CITY OF ALBUQUERQUE

**Re: West Mesa High School New Classroom Building
6701 Fortuna Rd NW
Request Permanent C.O. – Not Accepted
Engineer's Stamp dated: 4/13/2015 (J10D005)
Certification dated: 7-22-16**

SHEET TITLE:
**GRADING
PLAN**

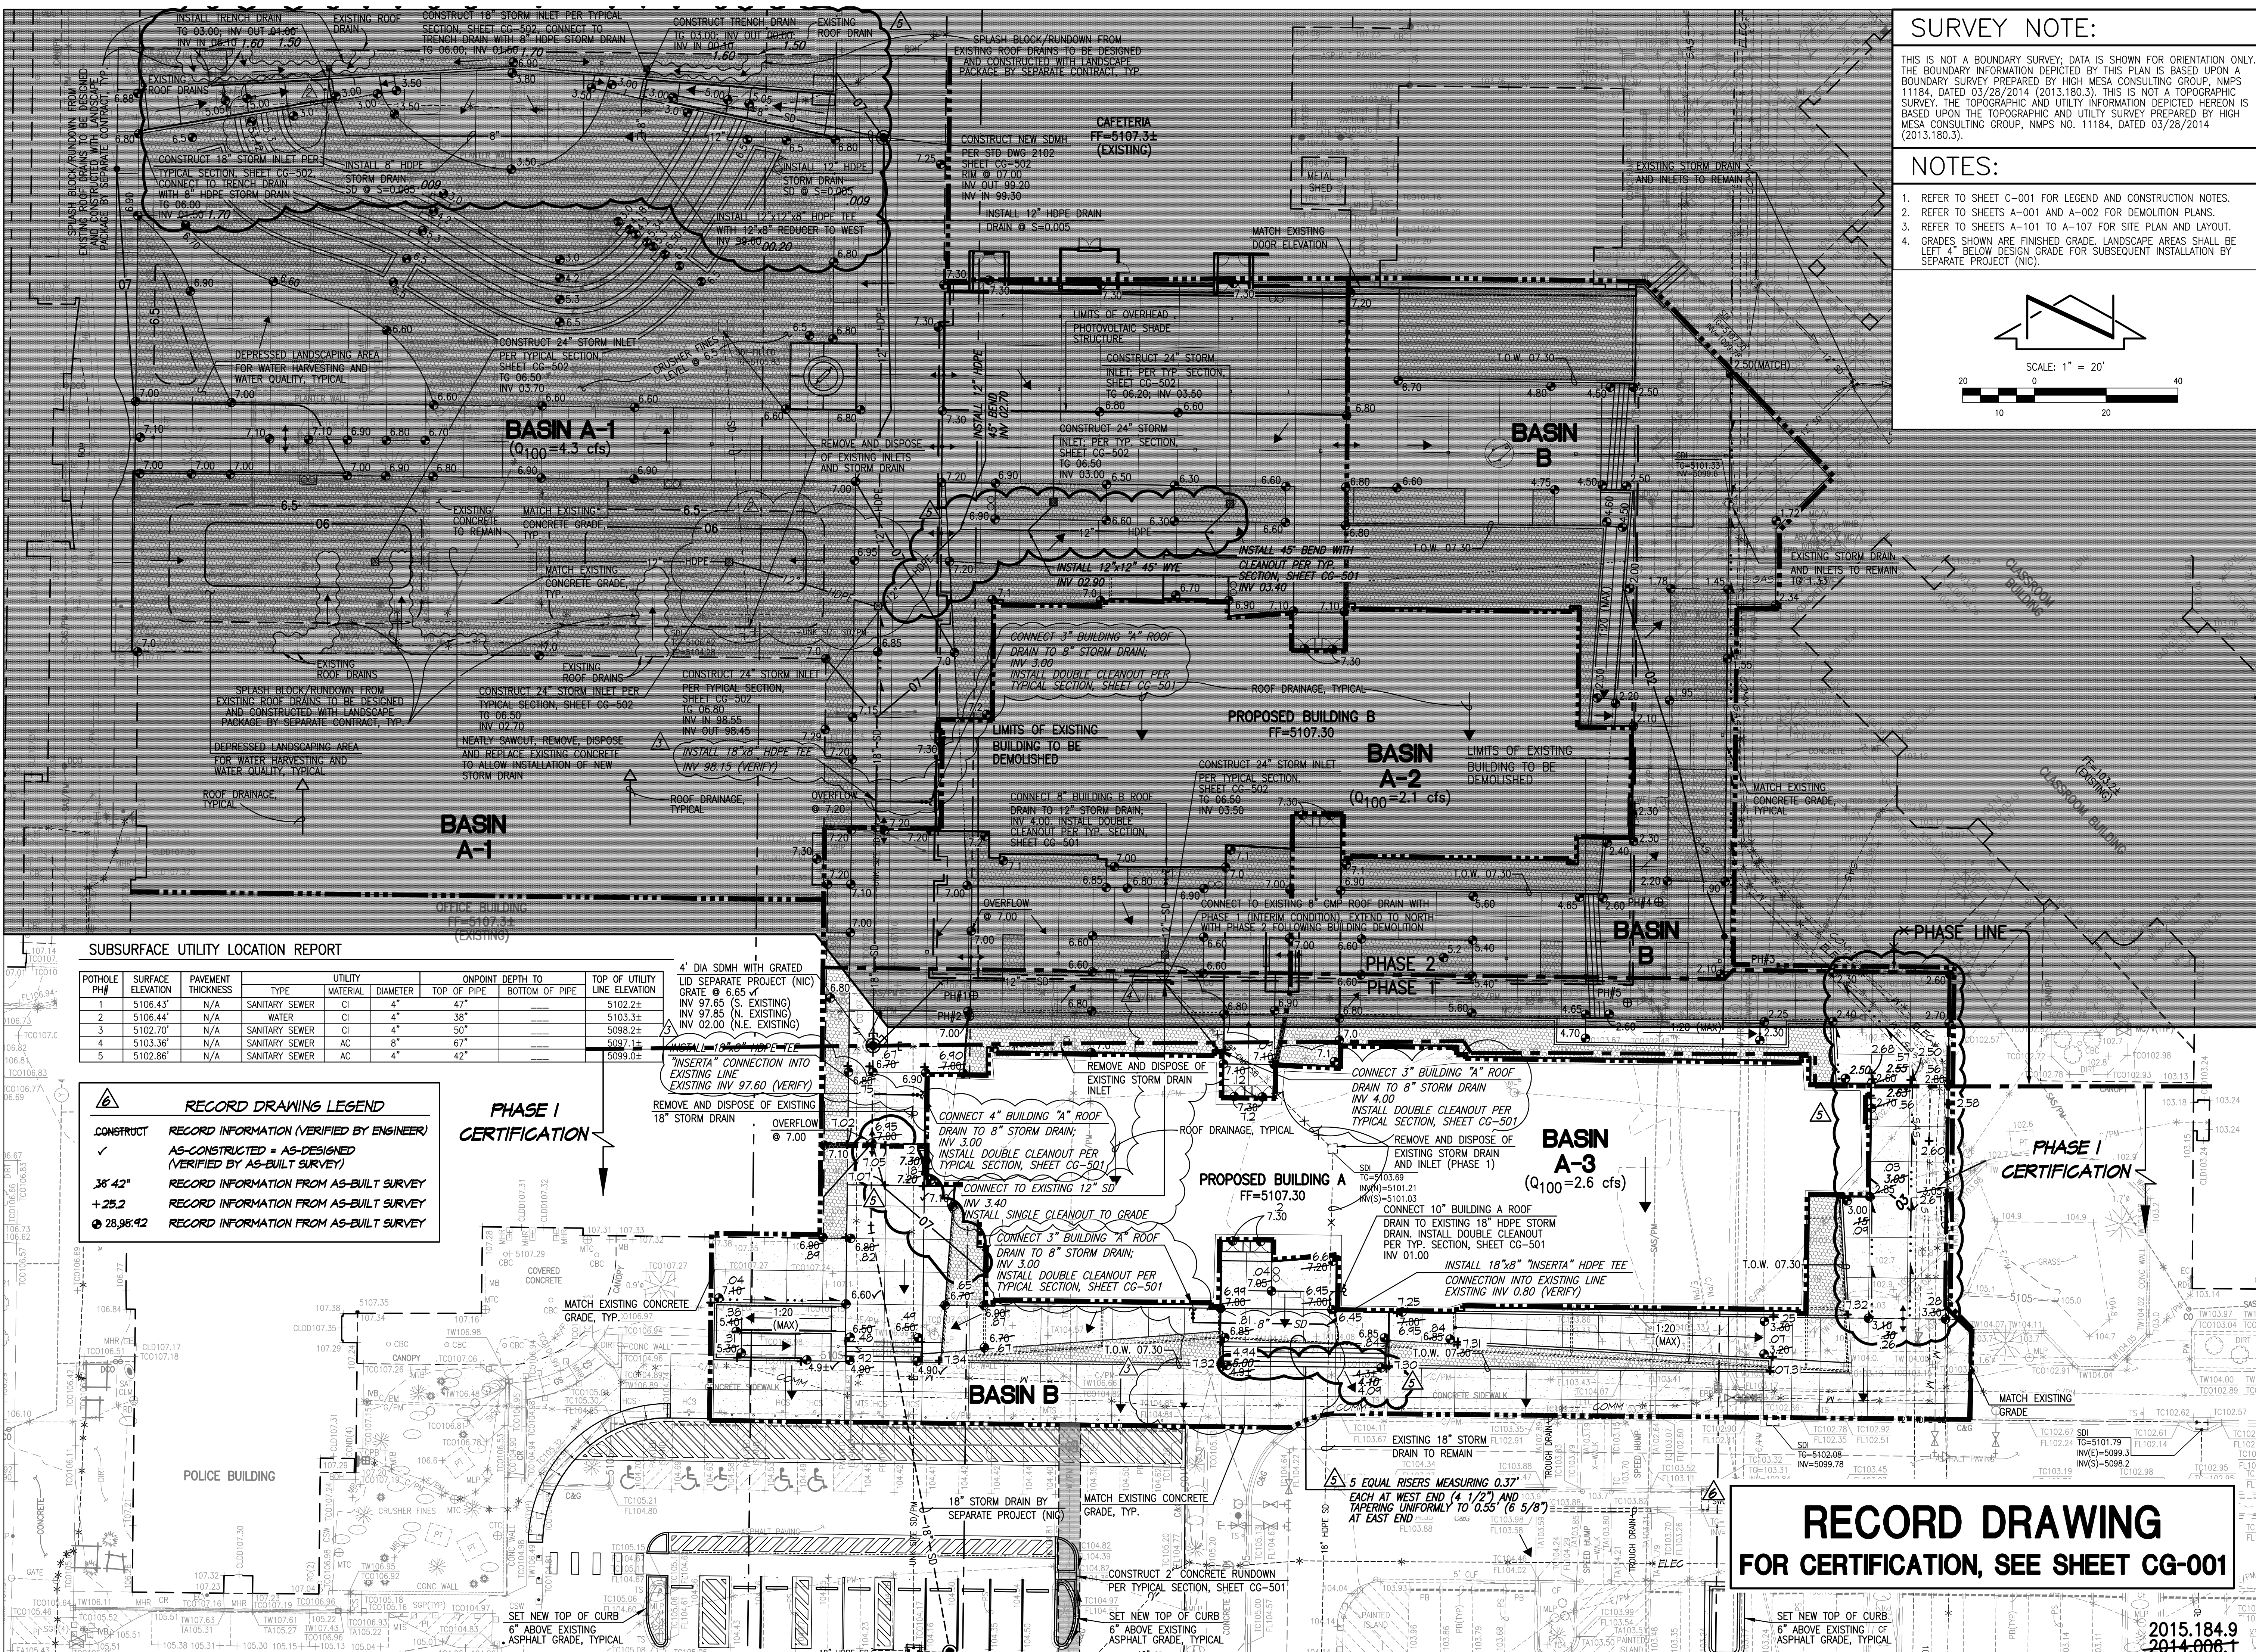
- The grated lid at the northwest corner of the building is covered. The fabric needs to be removed.
- There is an open trench on the north side of the building that needs to be backfilled.
- The parking lots are fenced off with construction equipment, trucks, materials, etc. thru-out the lots and drive entrances. The parking lots need to be opened and cleared.
